RWE Renewables UK Solar and Storage Limited ("RWE")

Proposed Peartree Hill Solar Farm Order (the "Proposed Development" and the proposed "Order")

Written Representation (Objection) on behalf of Albanwise Limited (Interested Party Reference PHSF-AFP001), Albanwise Synergy Limited, Albanwise Farming Limited, and Field House Renewables Limited¹, collectively ("Albanwise") (Interested Party Reference [REDACTED]) in relation to RWE's change request application submitted to the Planning Inspectorate on 10 September 2025 ("Change Request 9 Application" [REP2-149] setting out "Proposed Provisions") and accepted by the Examining Authority, as confirmed by letter dated 19 September 2025

OUTBOUND

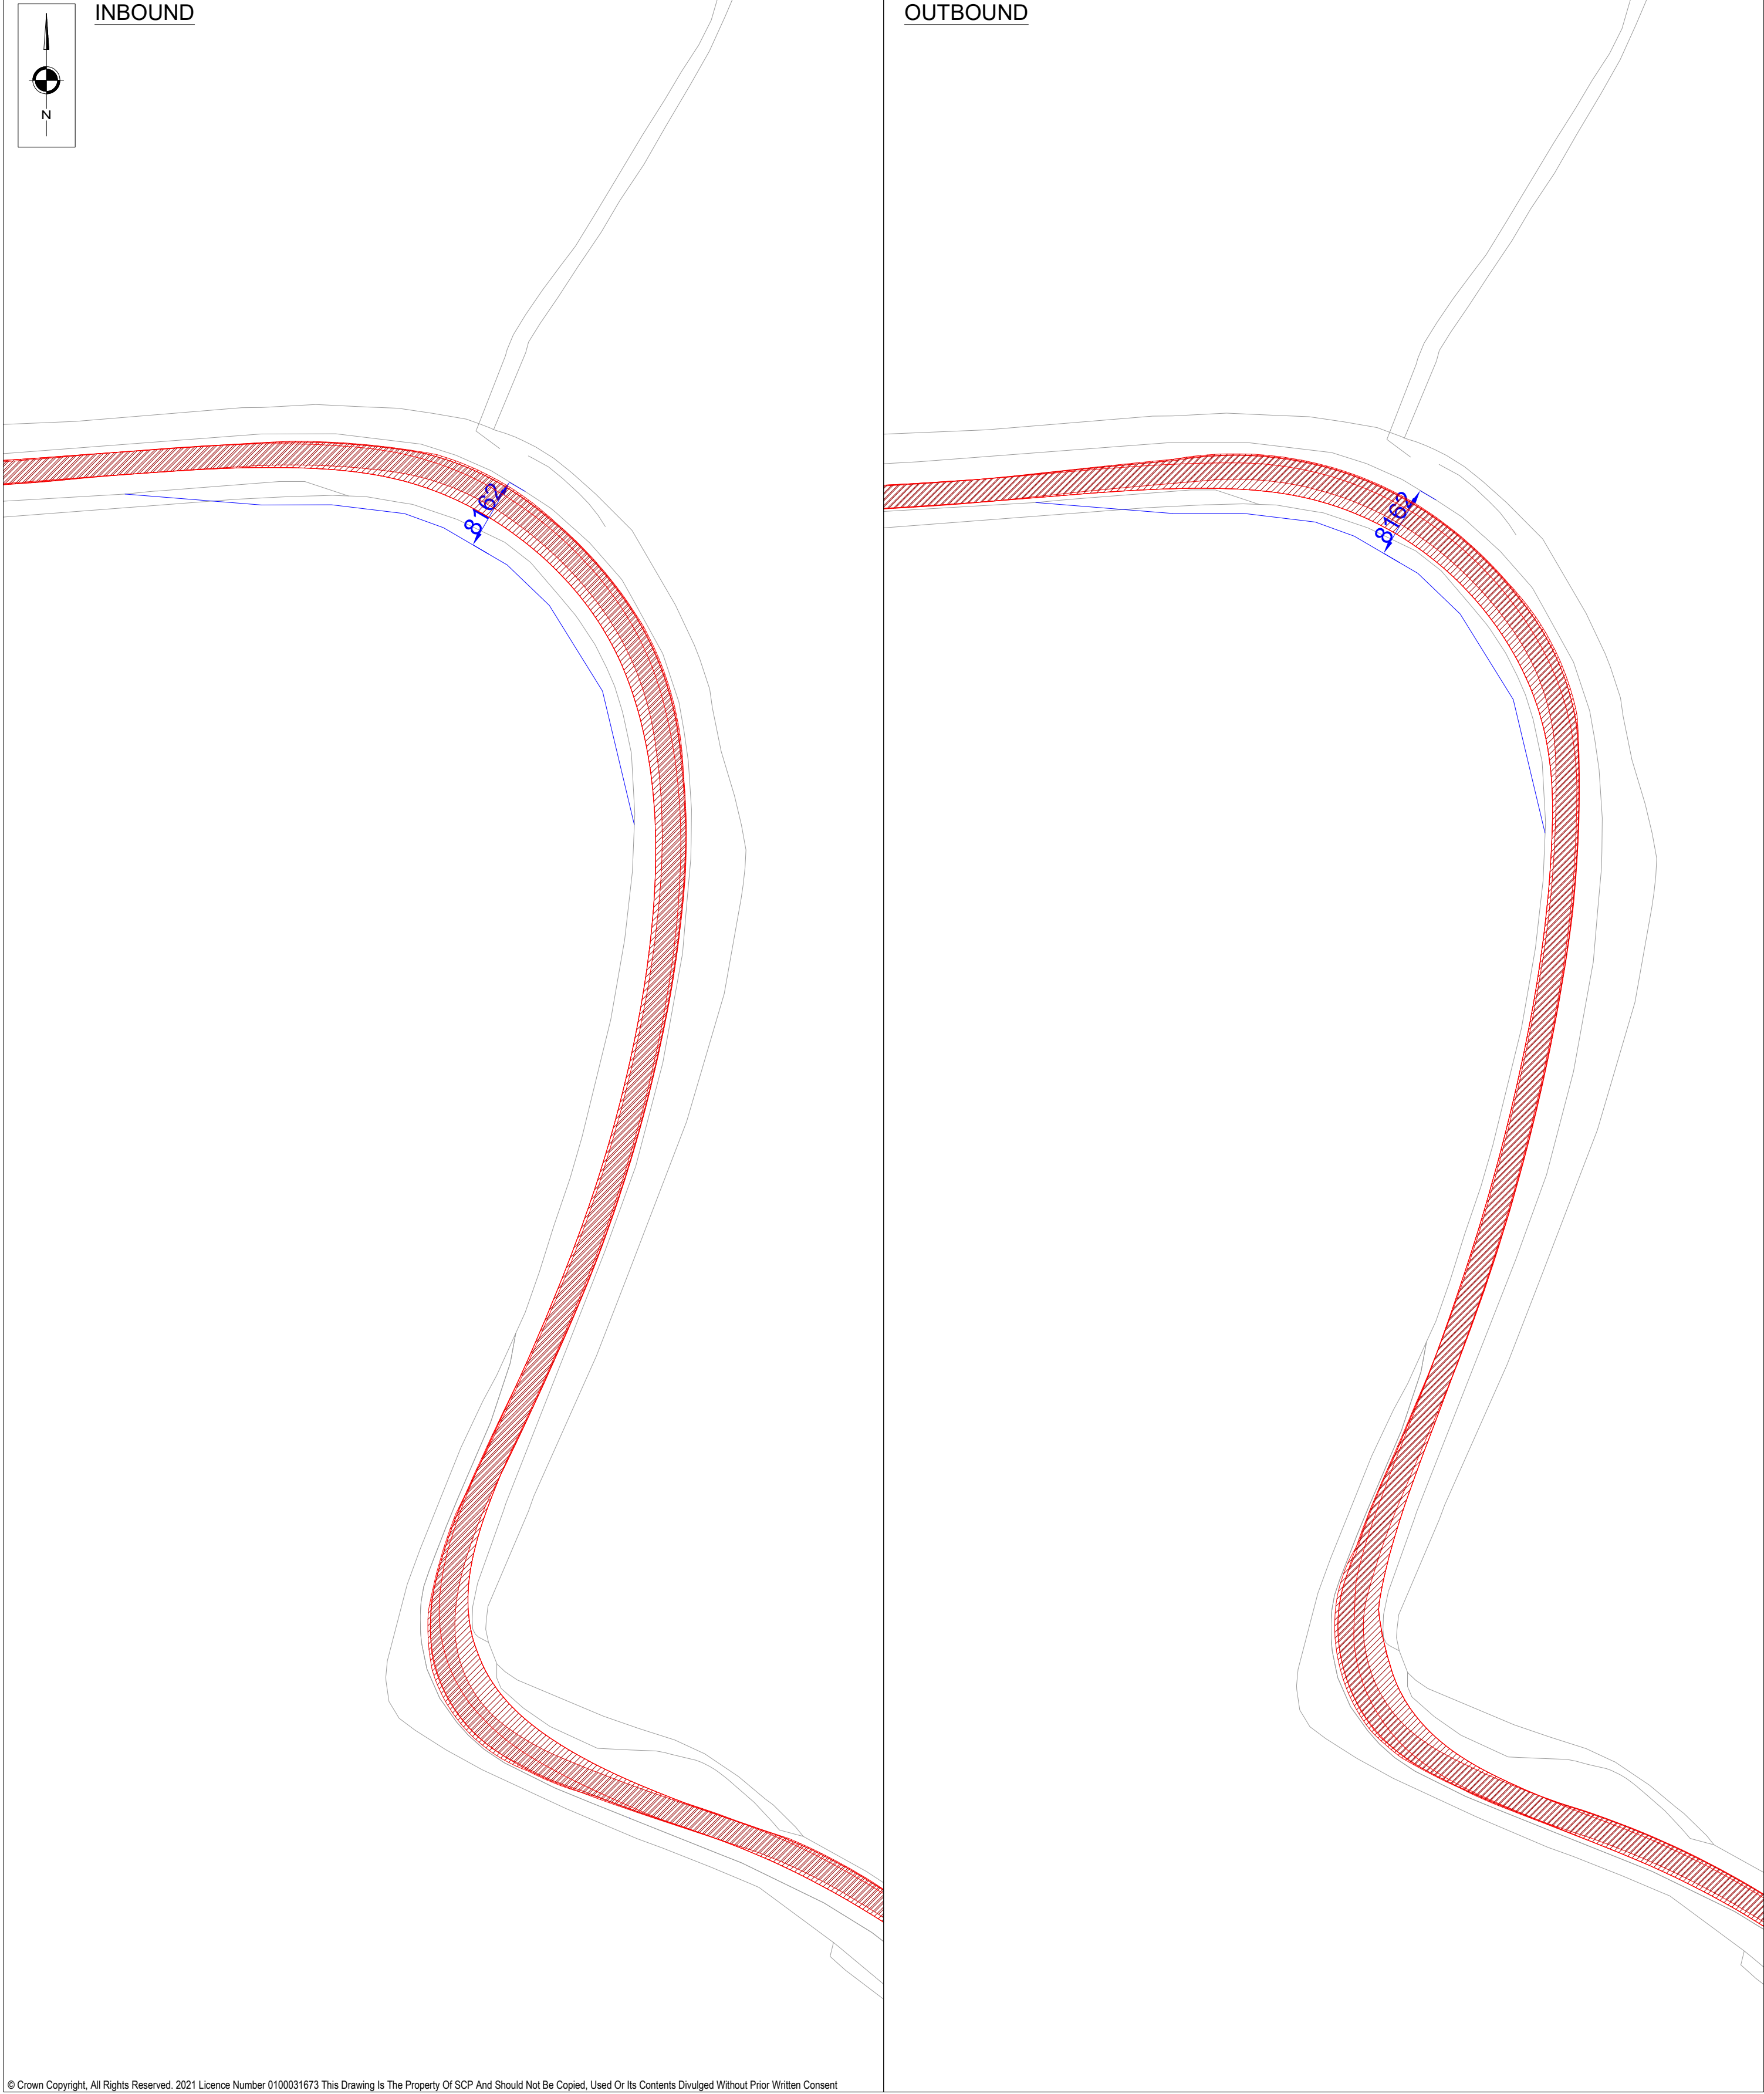
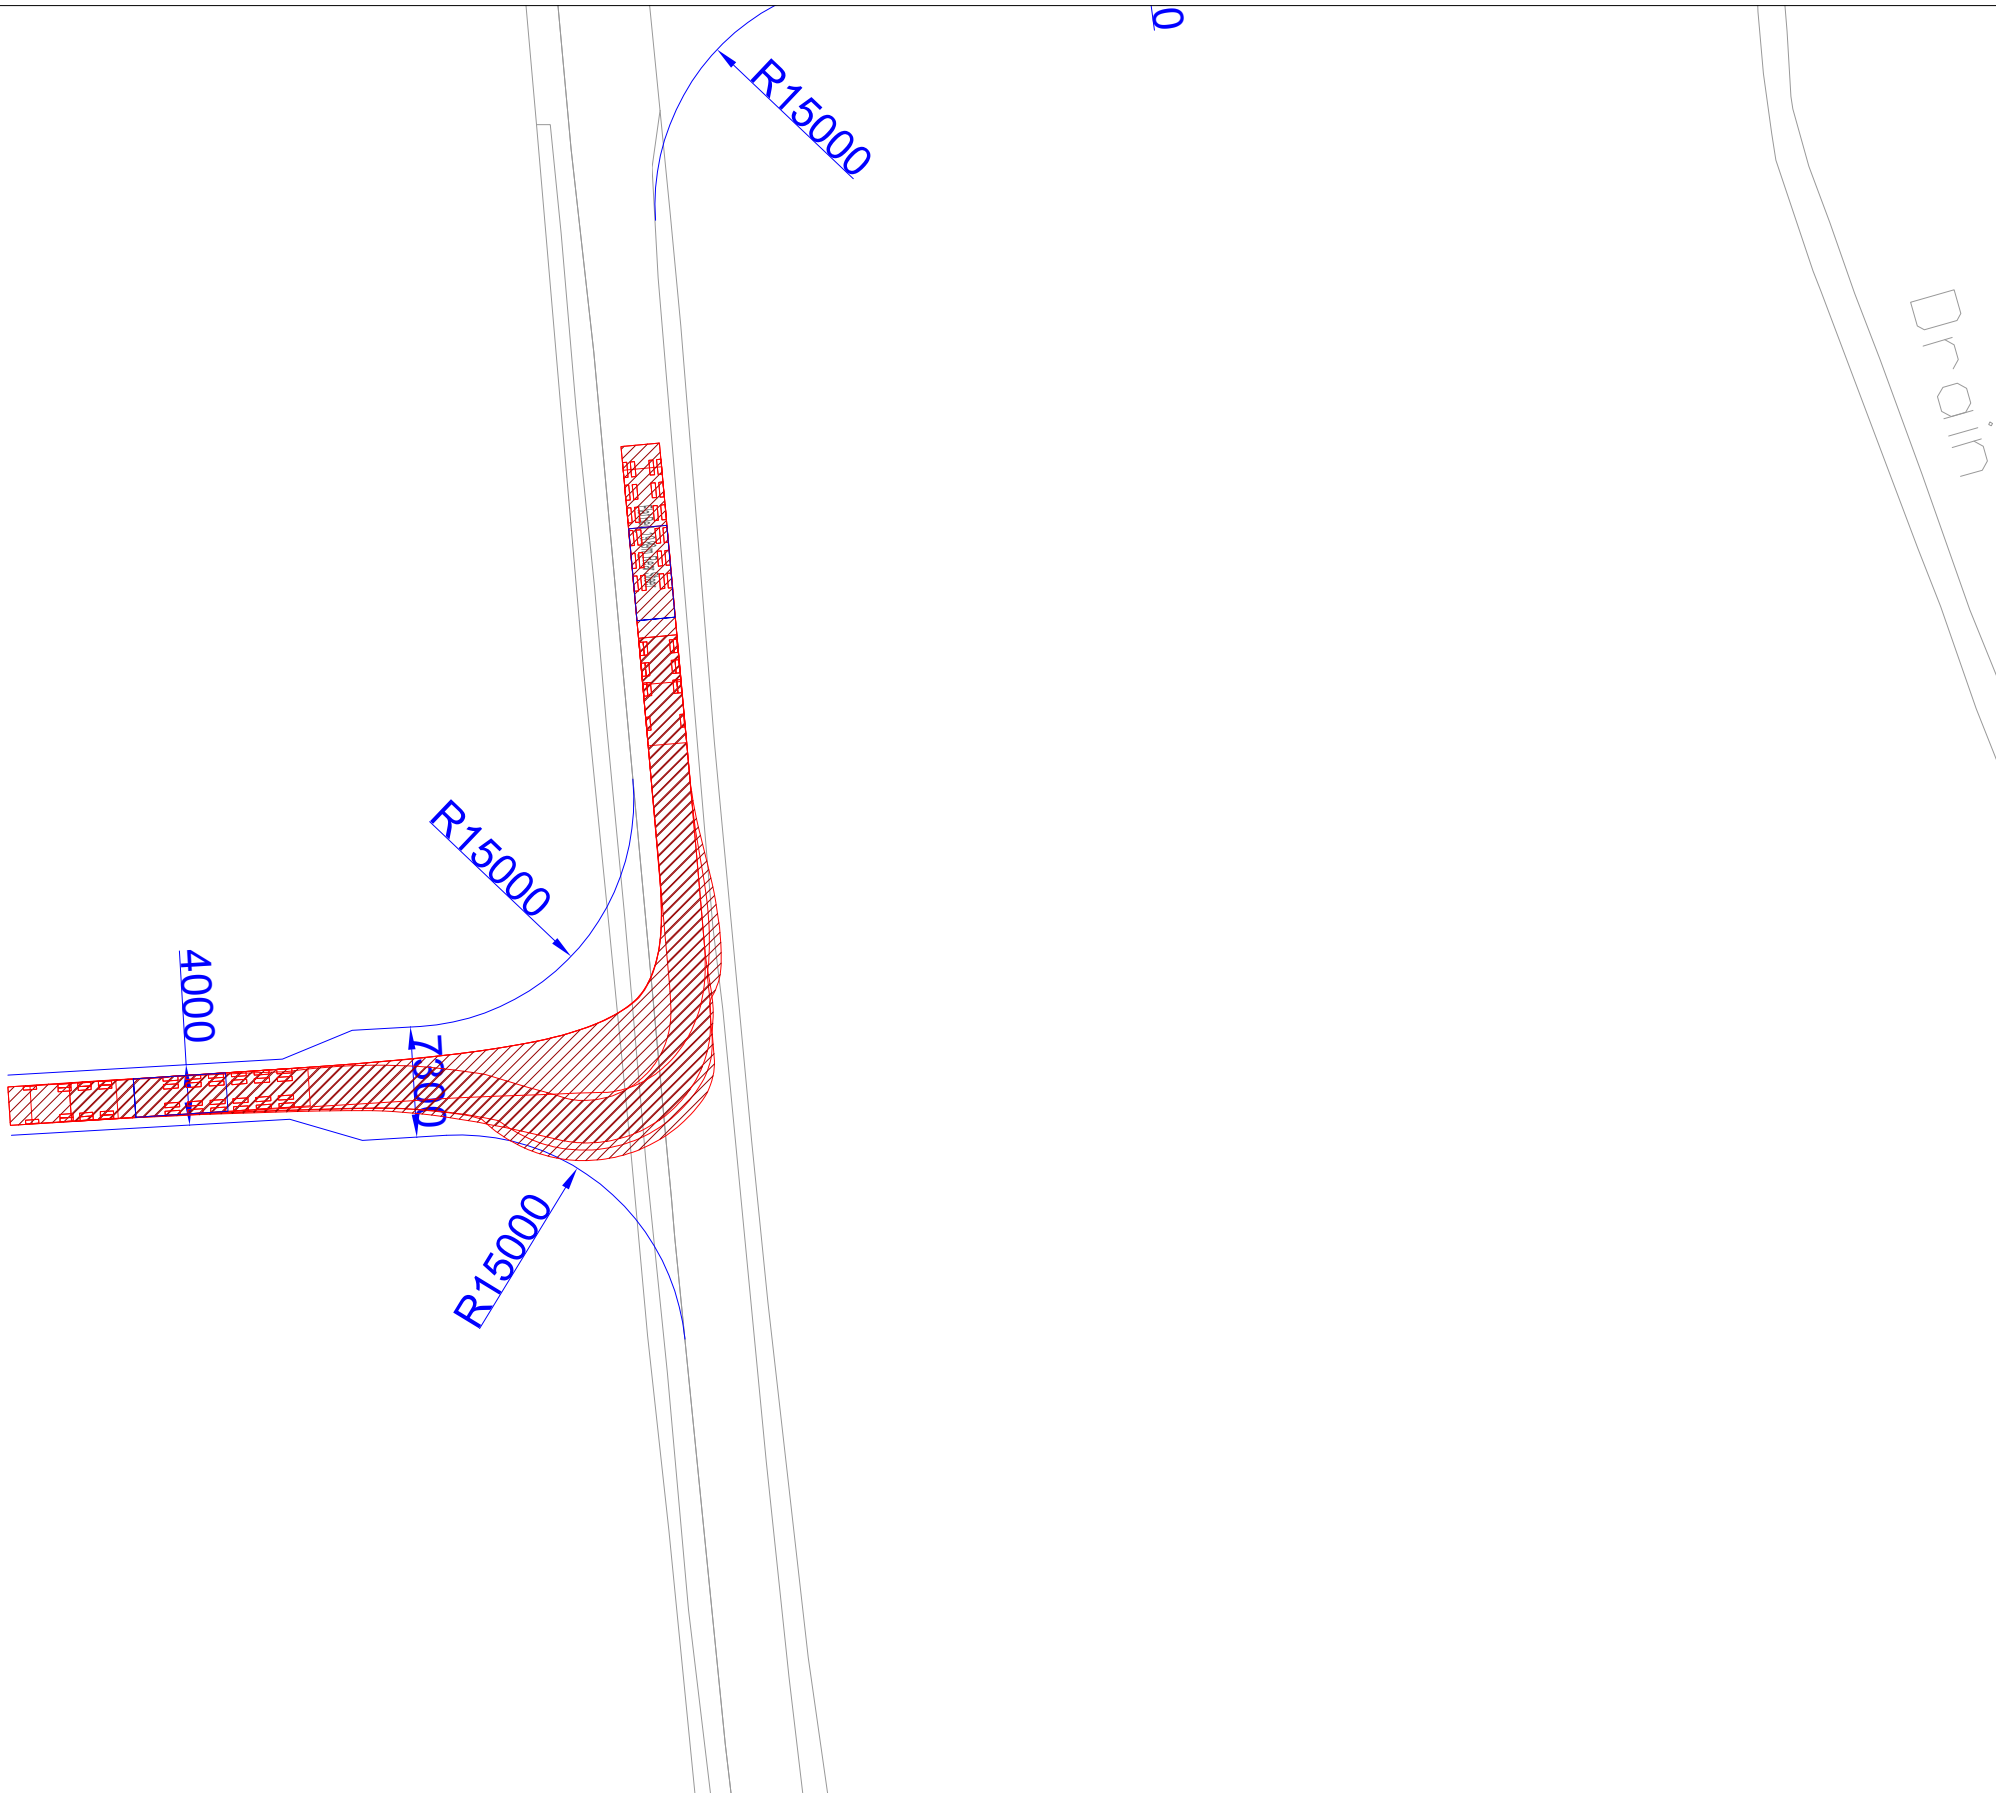
Tracking drawings provided by RWE showing vehicle movements at the junction indicate two locations where two-way traffic operation is not possible and incoming and outgoing vehicles would clash (or potentially crash) and the junction would therefore require special management measures to be put in place.

The potential risks associated with traffic blocking back to the A1035, include the following:

- A banksman has no legal powers to stop or hold traffic on the A1035 public road (note only the Police have the powers to do this);
- There is no indication where a banksman would be positioned. Given the inability for HGV traffic to pass unimpeded between the public road and the Existing Access Track, at least two banksmen would be required and given the complex constrained turns, they would need to be

- The positioning of banksman on the verge of 50mph speed road is considered very dangerous and does not appear to be compatible with Health & Safety regulations. For the banksman to be effective in identifying construction traffic, they would need to be positioned in close proximity to the existing hedge line in order to see traffic turning into the access junction. This puts them at the edge of the verge of a 50mph speed limit road;
- No detail on banksman shift patterns and communications protocols have been provided by SCP on RWE's behalf; and
- No detail had been provided as to how an RWE employed banksman would co-ordinate the movement of construction traffic travelling to/from the Proposed Peartree Development via the access junction alongside Field House Solar Farm construction traffic, agricultural traffic and residential traffic.

This last point is especially crucial and lies at the heart of Albanwise's safety concerns. The Transport Report shows that traffic management at this junction is essential because two HGVs cannot freely pass one another. The Principal Contractor on one project can easily ensure a safe system of work which schedules and manages deliveries for one project (and Albanwise have specifically addressed this in the Field House Construction Traffic Management Plan (CTMP)). The complications and safety concerns increase when there are two projects, working to different systems, overlapping one another in the same physical space and no detail as to how this would be managed has been provided by RWE, other than a reference to Requirement 16.
